**EI PASO COUNTY – PLANNING & COMMUNITY DEVELOPMENT
MINOR MODIFICATION TO AN EXISTING WIRELESS FACILITY
VERIZON WIRELESS SITE NAME: CSP CALHAN**

Site Plan/Project Name: CSP CALHAN – EMERGENCY 2 WAY RADIO

Request: Development site plan approval for minor modification.

This project consists of installing a new UHF monopole antenna to an existing 100' telecommunications tower and running the required power/signal cable from the equipment shelter to the antenna. New antenna will be installed to the tower with a stand-off bracket such that the tip height of the antenna will not exceed the approved tower height of 100'.

T1

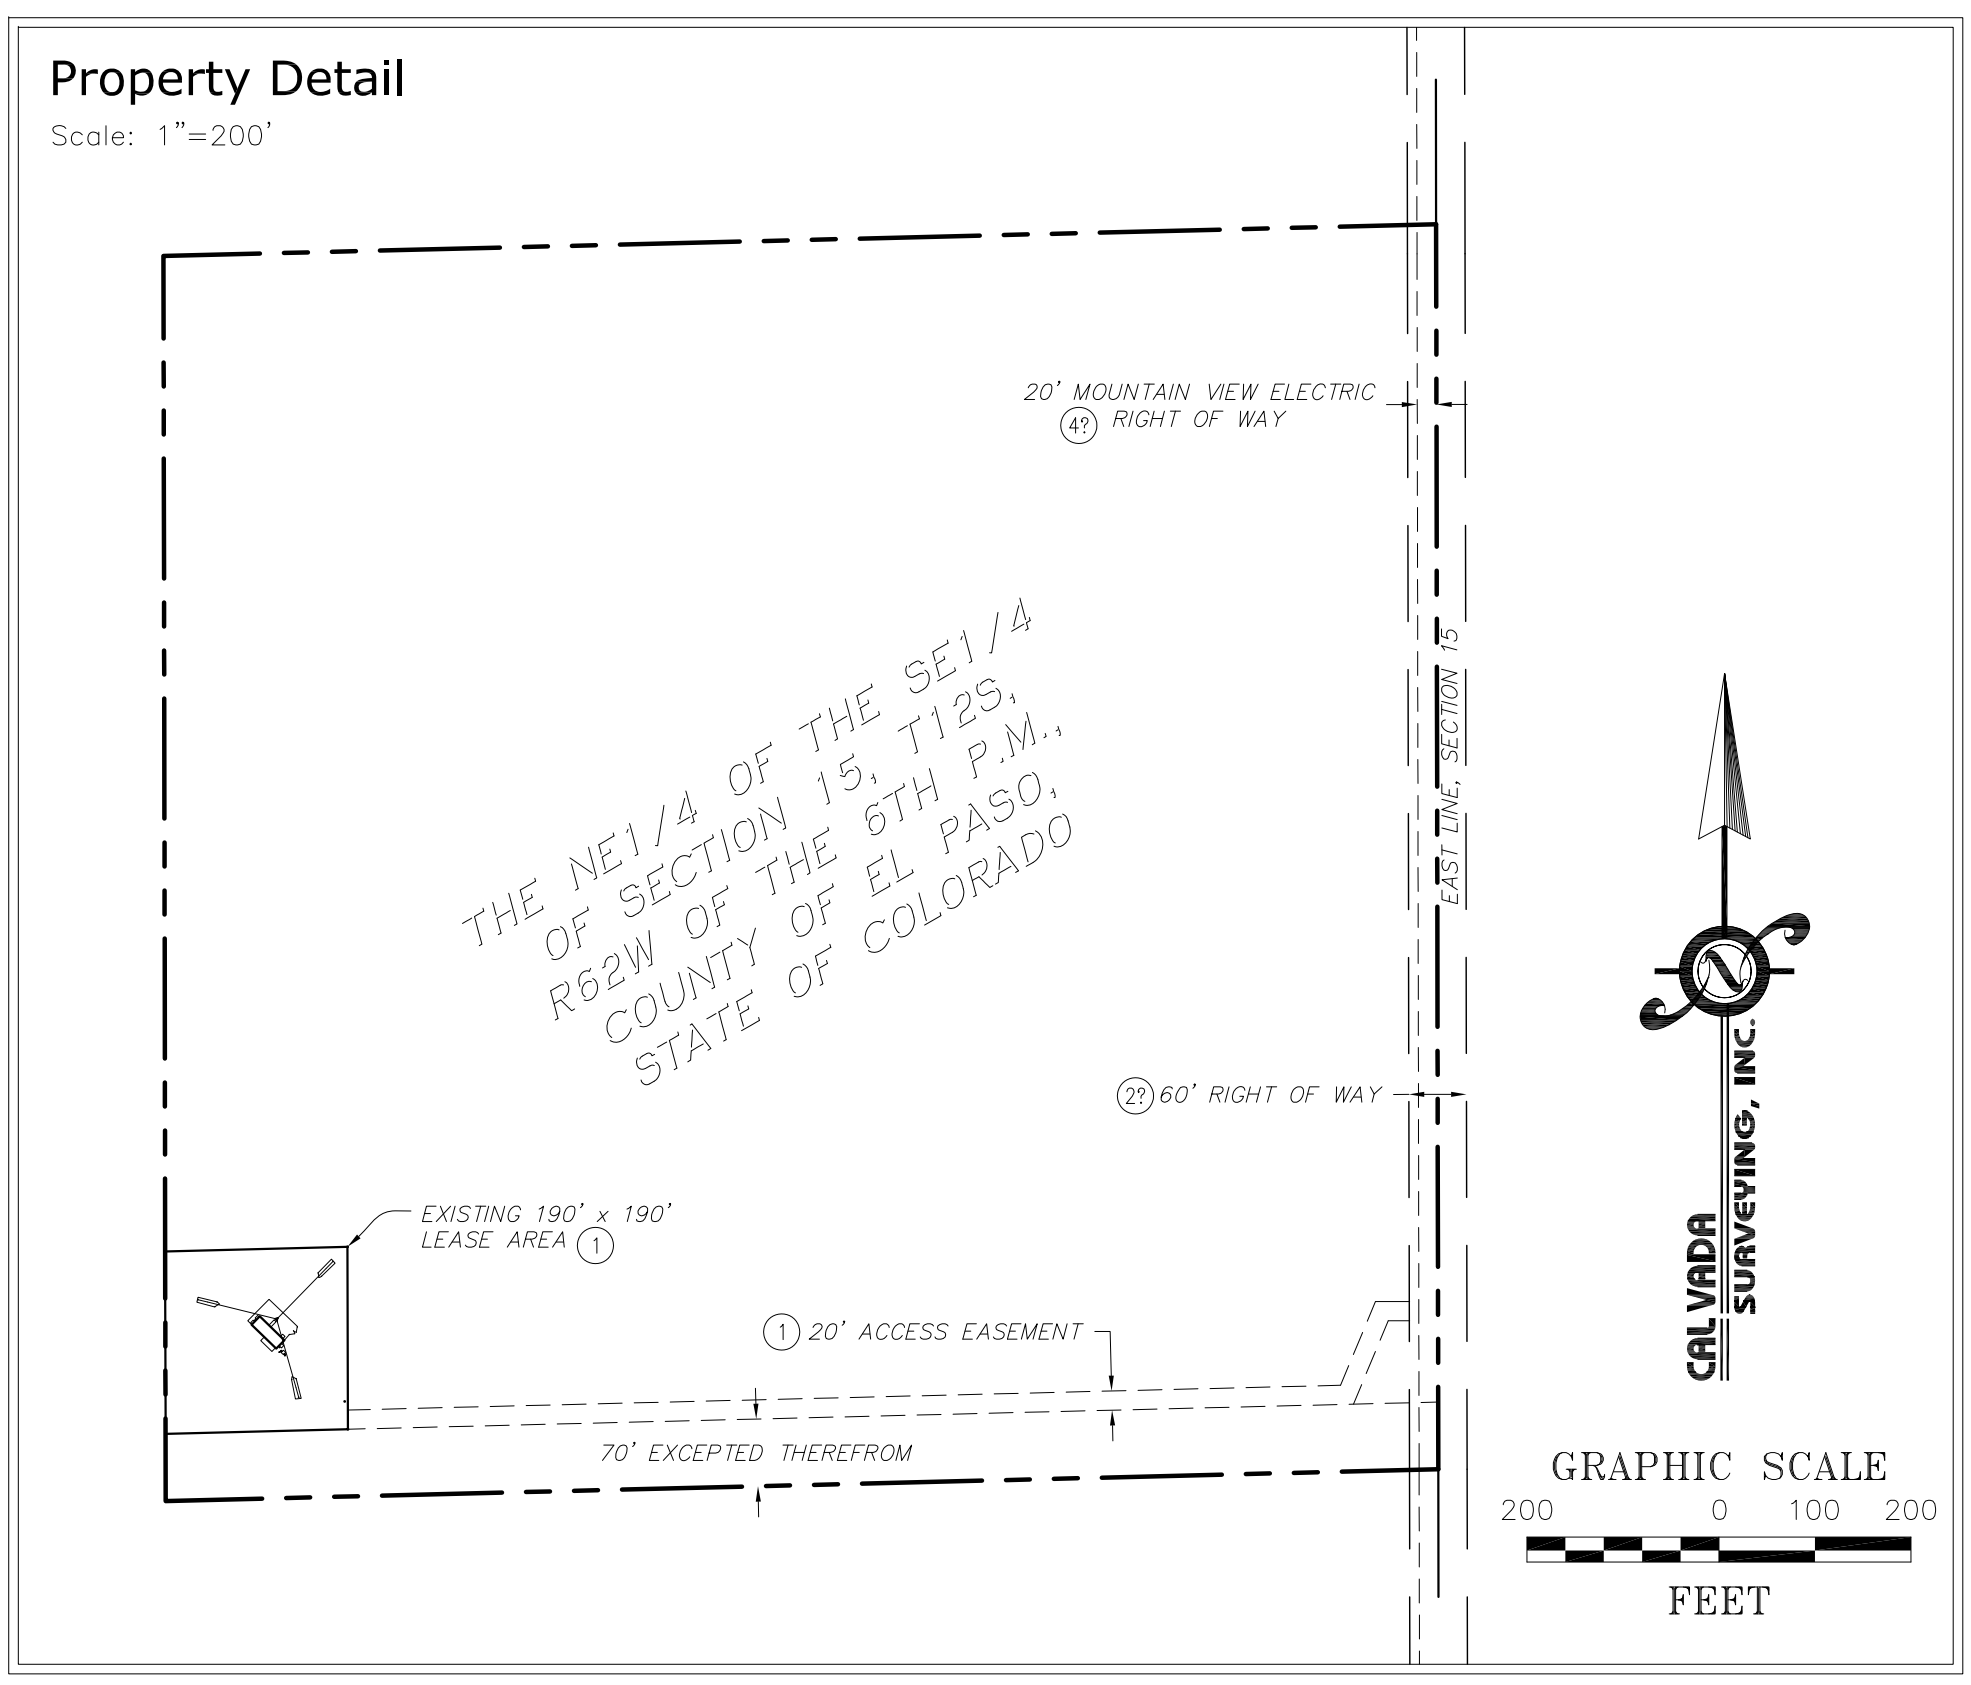
This site plan should show the subject property and the location of all existing structures in relation to the property boundaries (provide dimensions to the closest property line). Please also show how you access this site. If access is taken from the adjacent lot, please provide a copy of the access easement.

Sheet: **LS1**

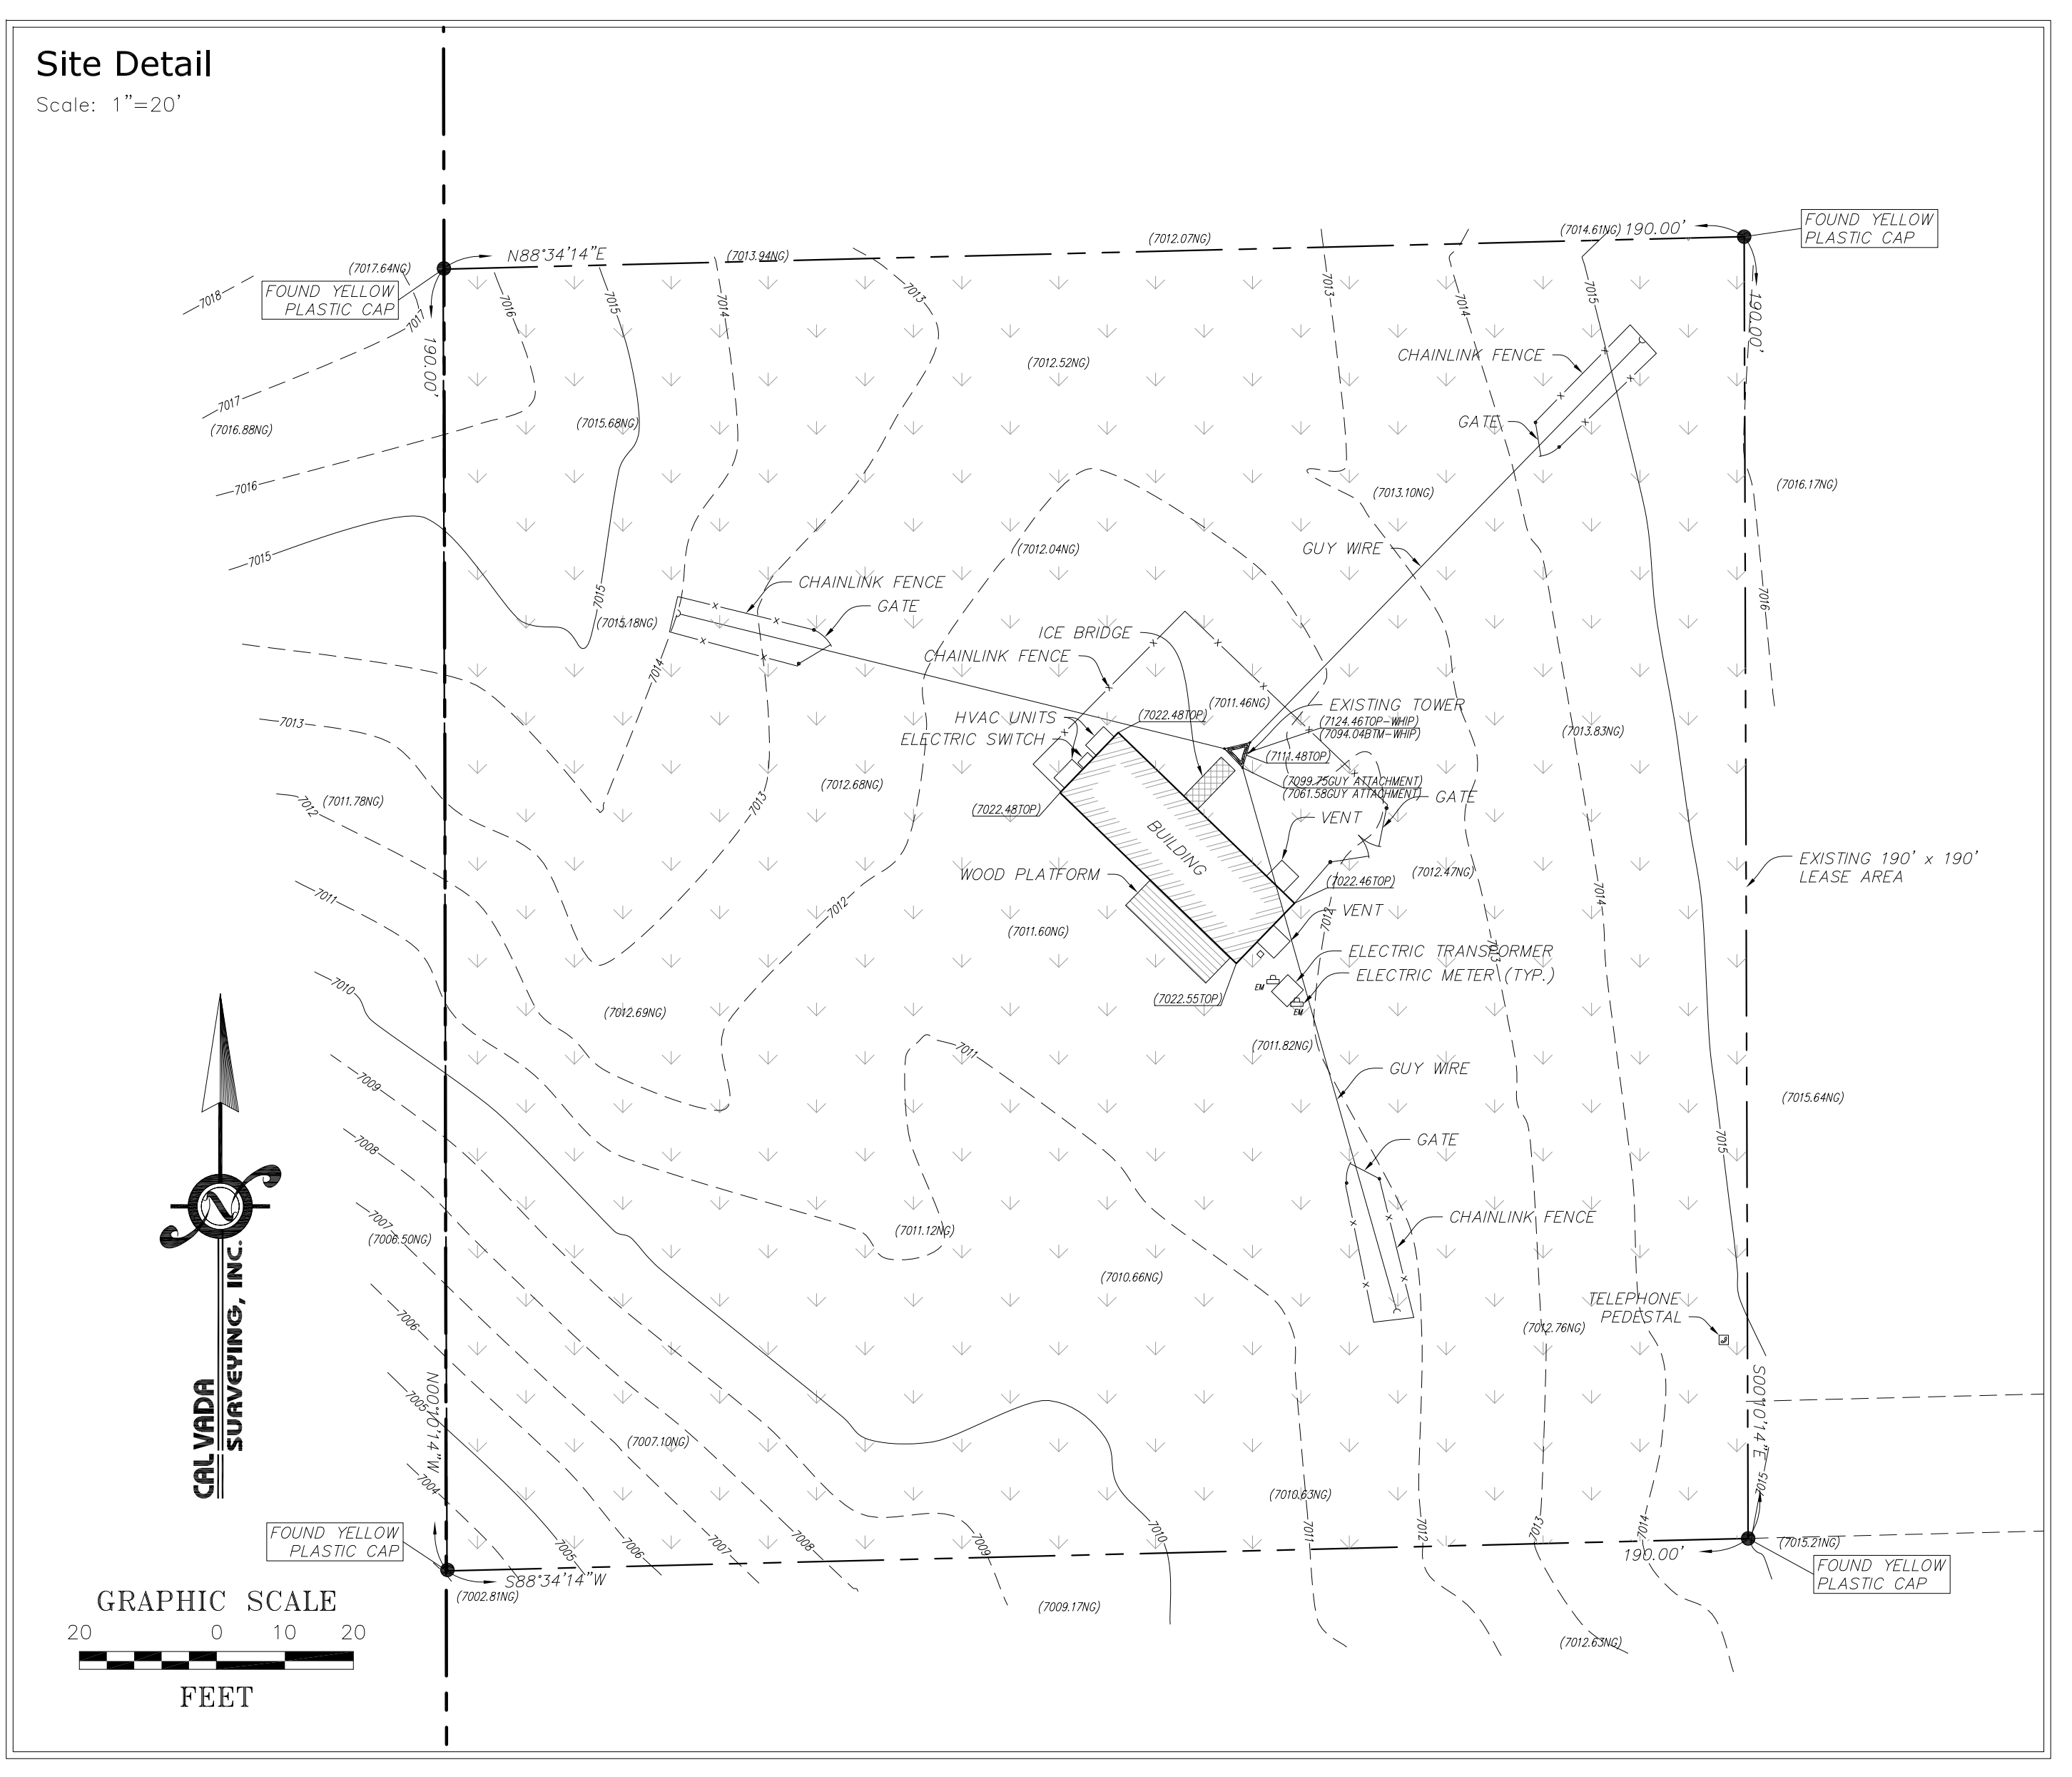
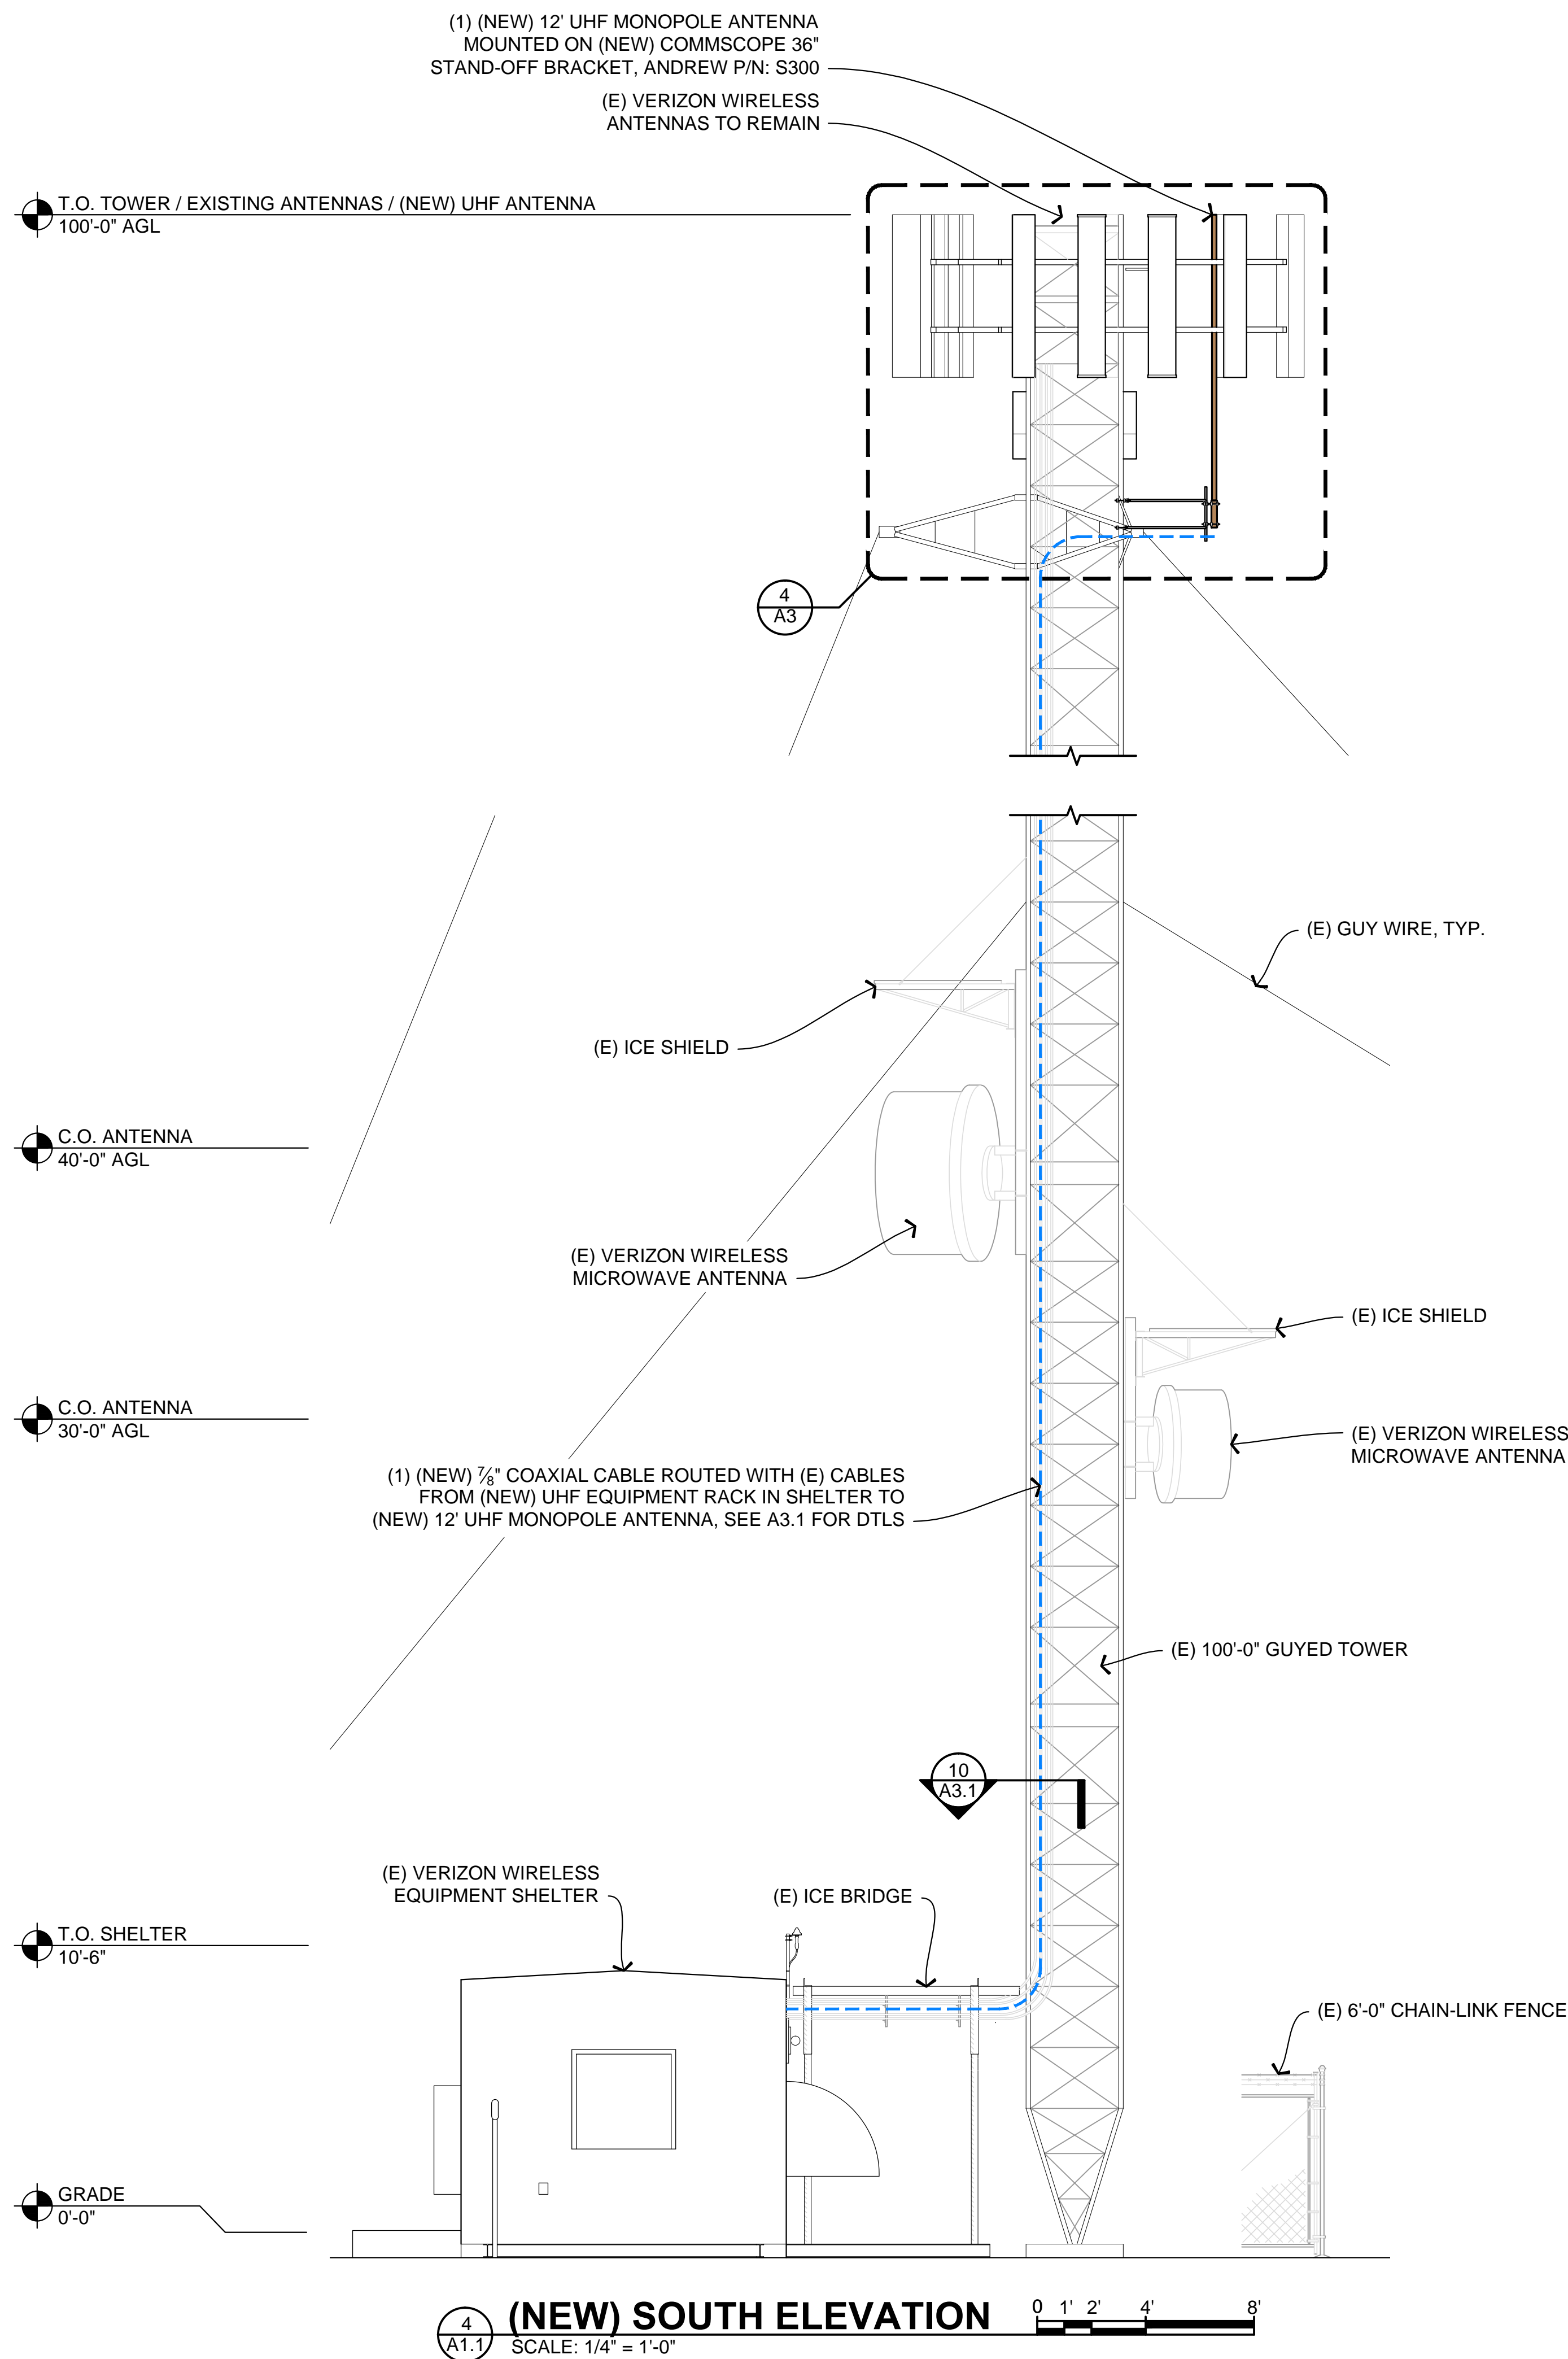
site plan needs to indicate property lines and distance structures are from property lines
